Recommendation Report for Planning Permission for Works or Extension to a Dwelling

REF NO: BR/318/19/HH

LOCATION: 63 Nyewood Lane
Bognor Regis
PO21 2SD

PROPOSAL: Proposed garden wall.

Proposed South Elevation

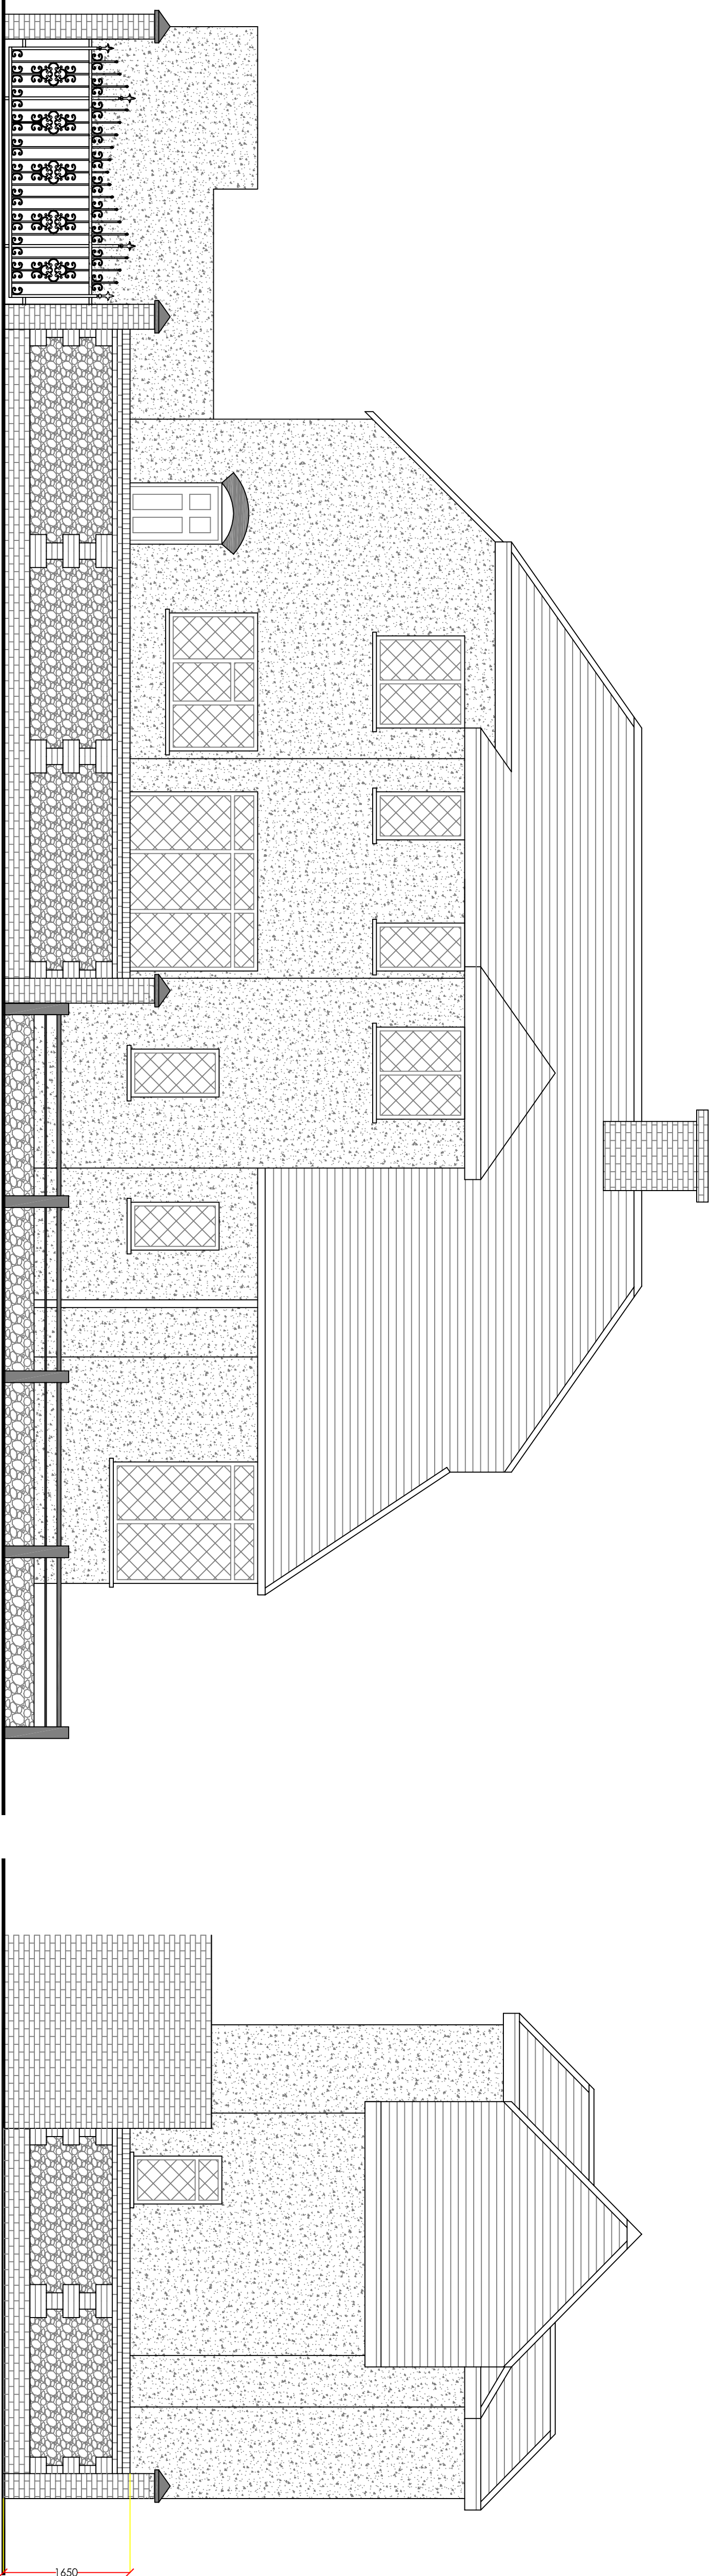
The proposal retains the existing treatment and intends to construct a brick wall to run along the remaining southern elevation. The wall will be constructed to a height of 1.6m with 3 pillars to a height of 2.15m. It will extend along the southern elevation with a width of approximately 9m. To the west it will have a depth of 4.75m to meet with an existing wall.

There are examples of similar boundary treatment nearby with a brick wall opposite at 61 Nyewood Lane, Harrington House and at the neighbouring property at 2 Shelley Road. Whilst the pillars will be relatively tall, it is not considered to appear unduly dominant or appear significantly out of character as a result of the examples within the vicinity.

The wall will be constructed of brick and flint to match that which exists. It is not considered these materials would be out of character with a mixture of brick and fencing in the surrounding area.

Proposed Garden Wall Planning
Date October 2019
Scale 1:50

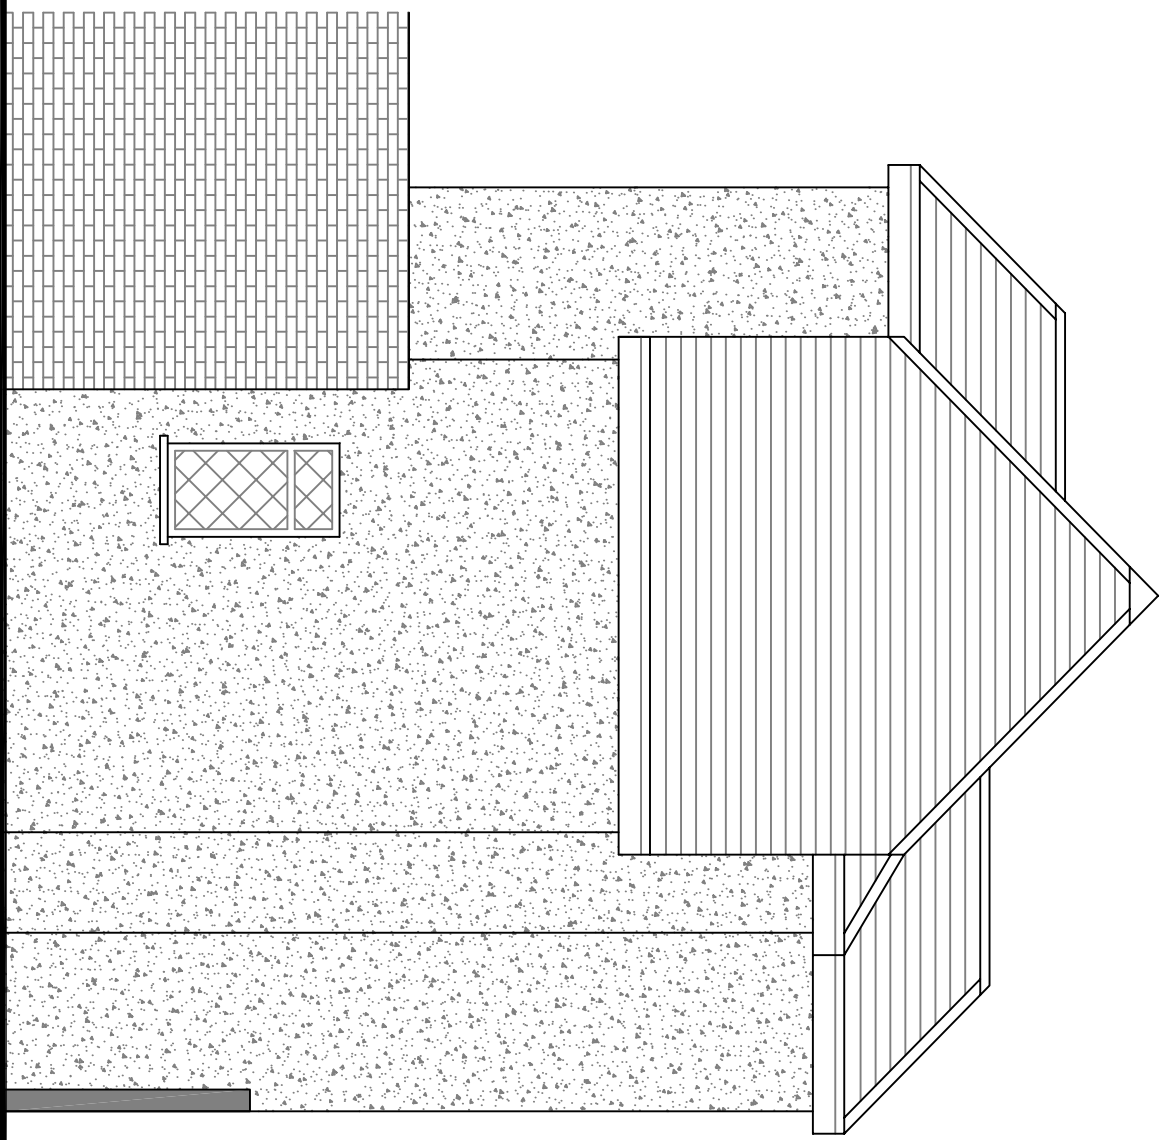
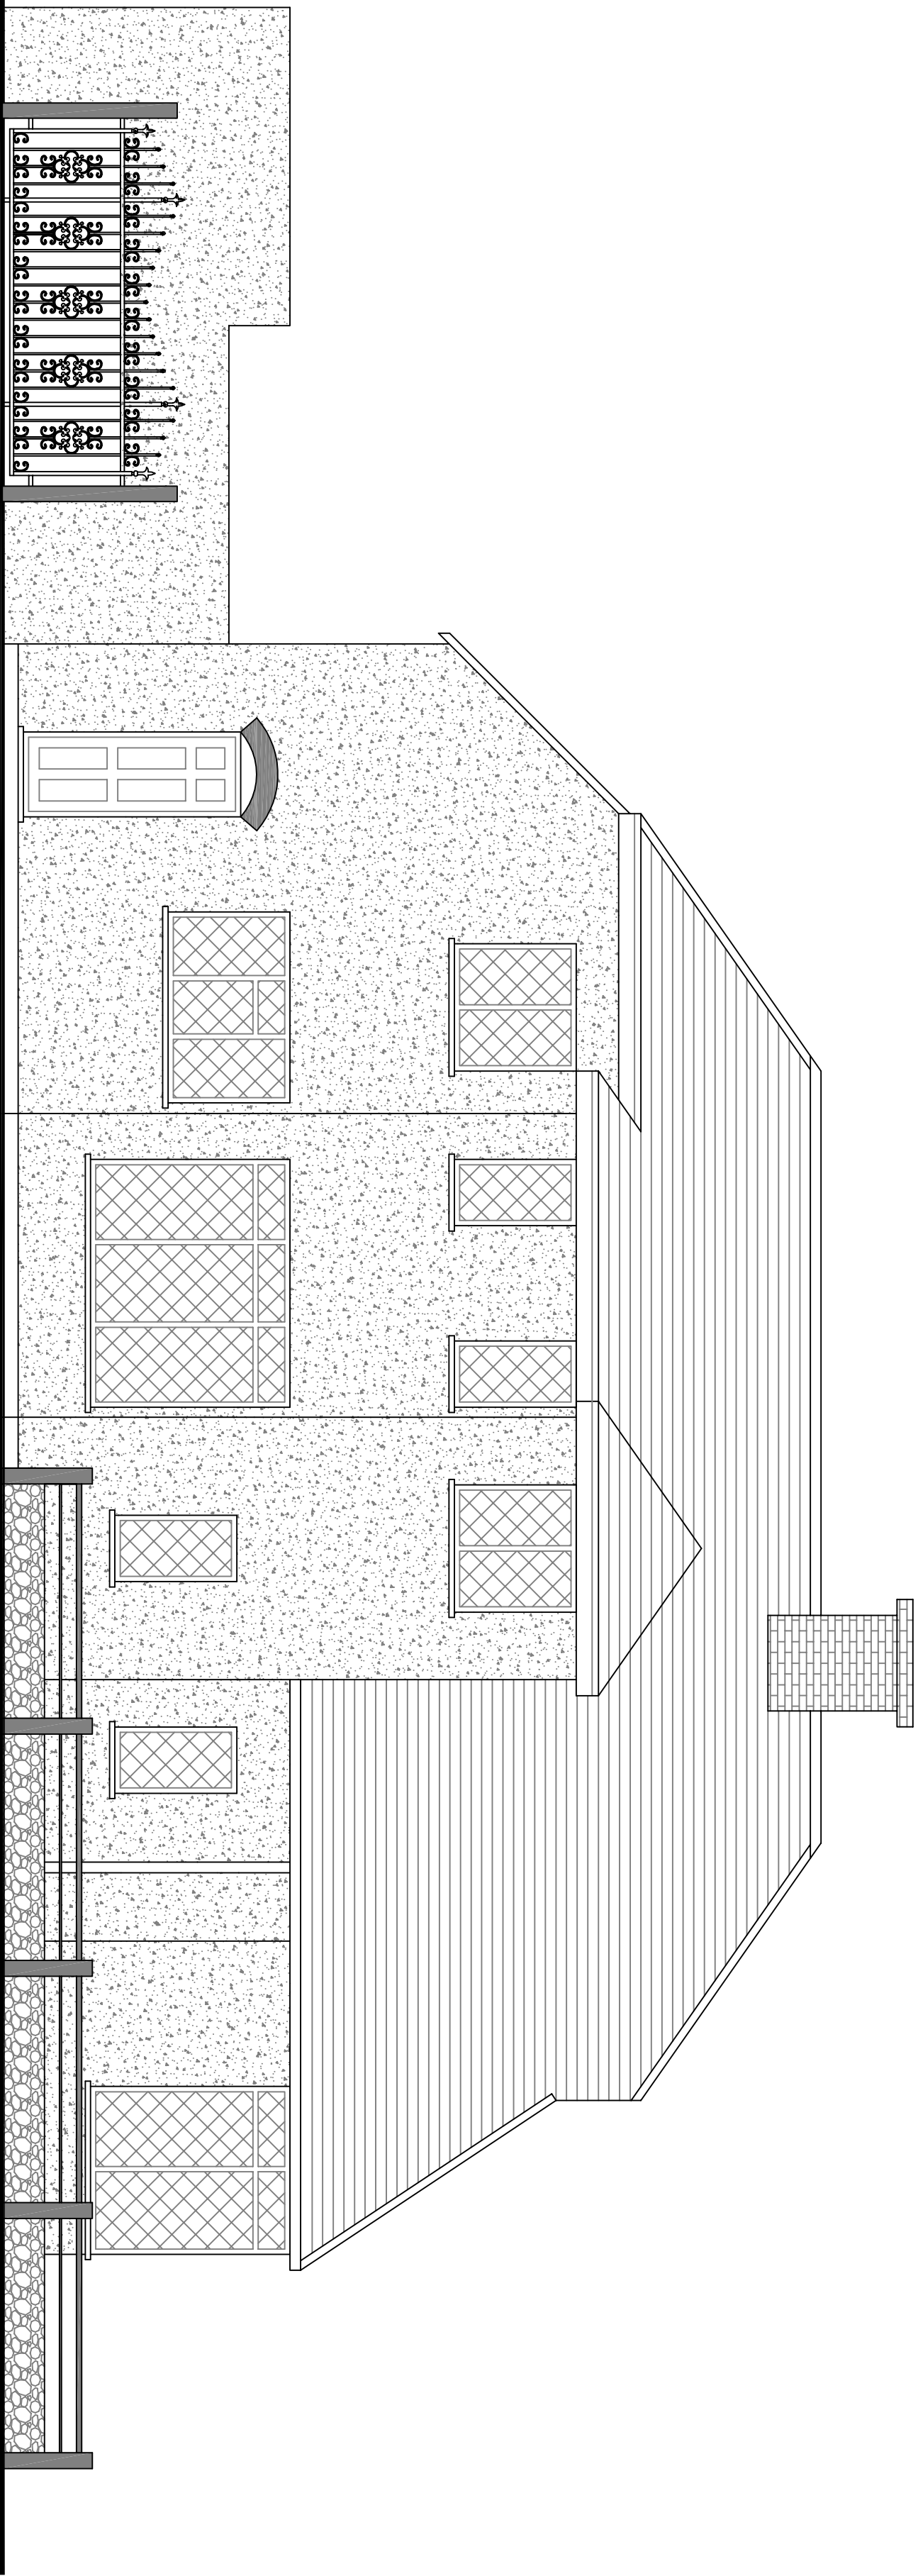
The property is located to a corner at Nyewood Lane and Shelley Road and is therefore highly visible. The wall will run along the southern elevation of the property which fronts Shelley Road. There will also be a section of wall to the western elevation on the boundary between the host dwelling and 2 Shelley Road.
